Addendum No. 1

RE: Contract # C204350

Nash County (B-5980/BR-0039/BR-0036)

I-95 AT SR-1544 (HALIFAX RD), BRIDGE #41 OVER I-95 ON NC-33,
AND BRIDGE #224 OVER I-95 ON SR-1510.

Drawing file: 400 Structure Plans - Bridges / 400_05_S03_B5980_SMU_LOC.pdf

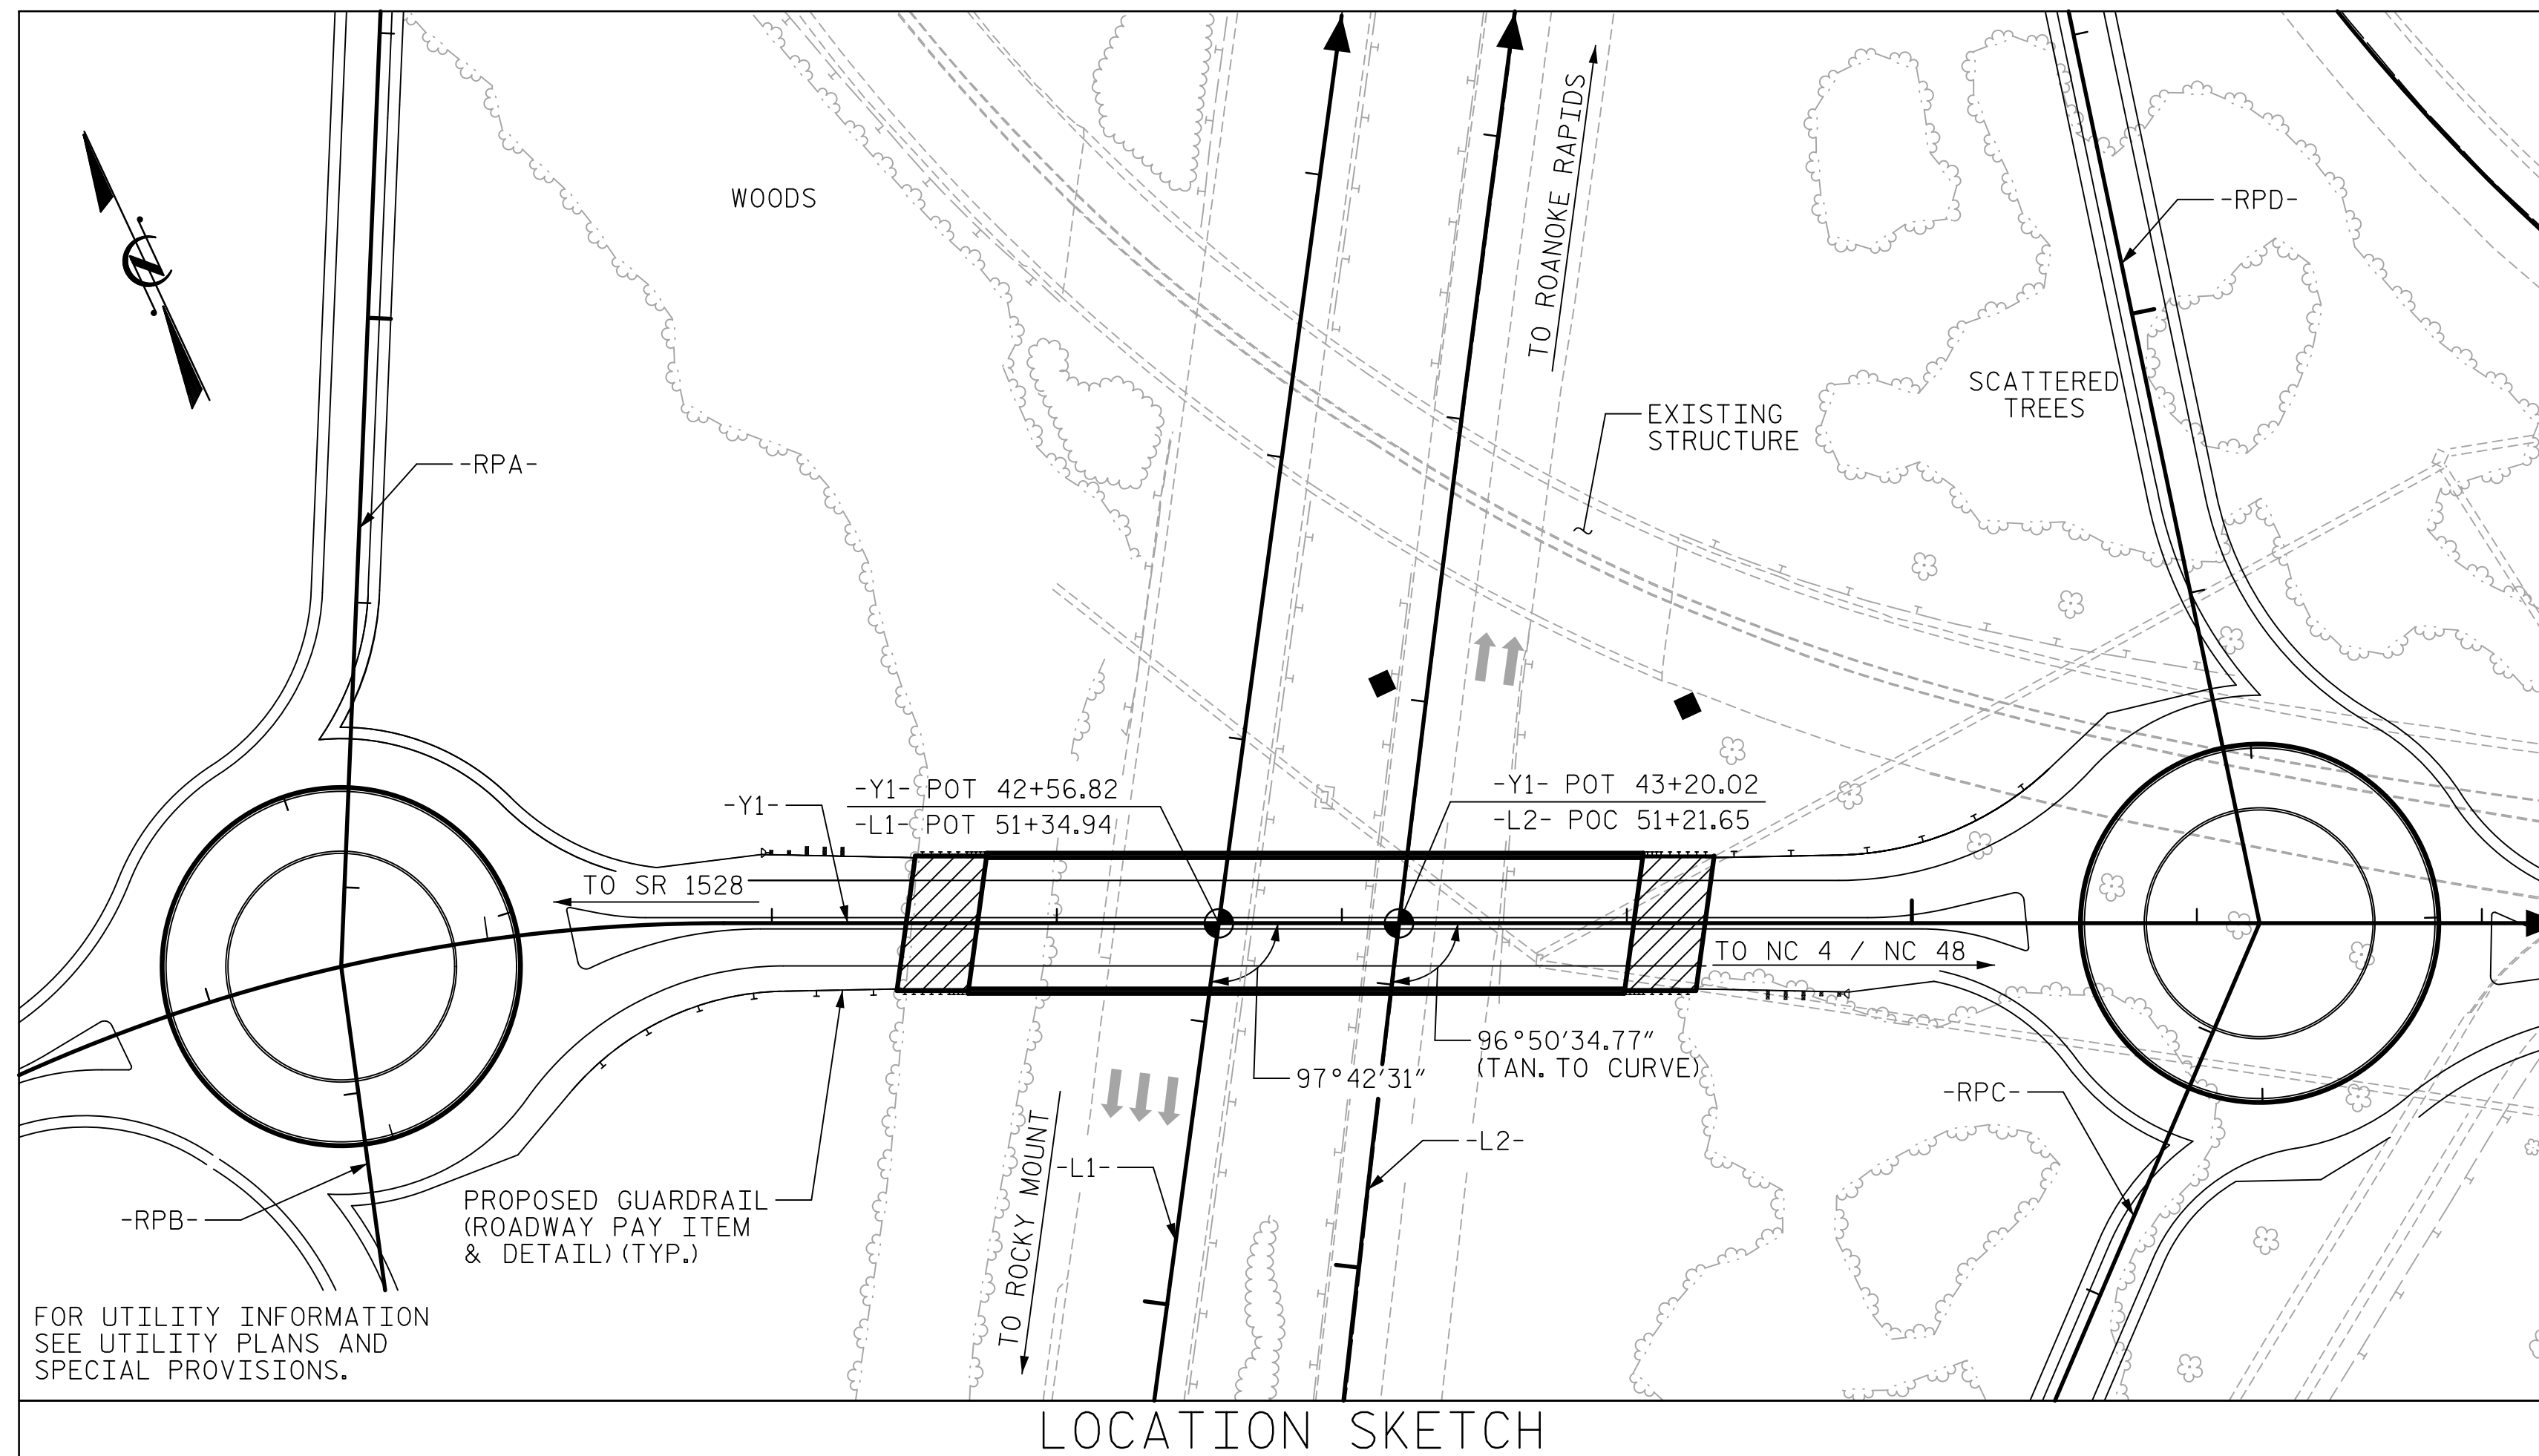
Sheet No.	Revision
S-03	New item added to the Bill of Materials reflecting pay item addition shown below

<u>Item</u>	<u>Description</u>	<u>Old Quantity</u>	<u>New Quantity</u>
0325-8035000000- N-402	REMOVAL OF EXISTING STRUCTURE AT STATION 17+07.50 - Y2-	New Item	Lump Sum
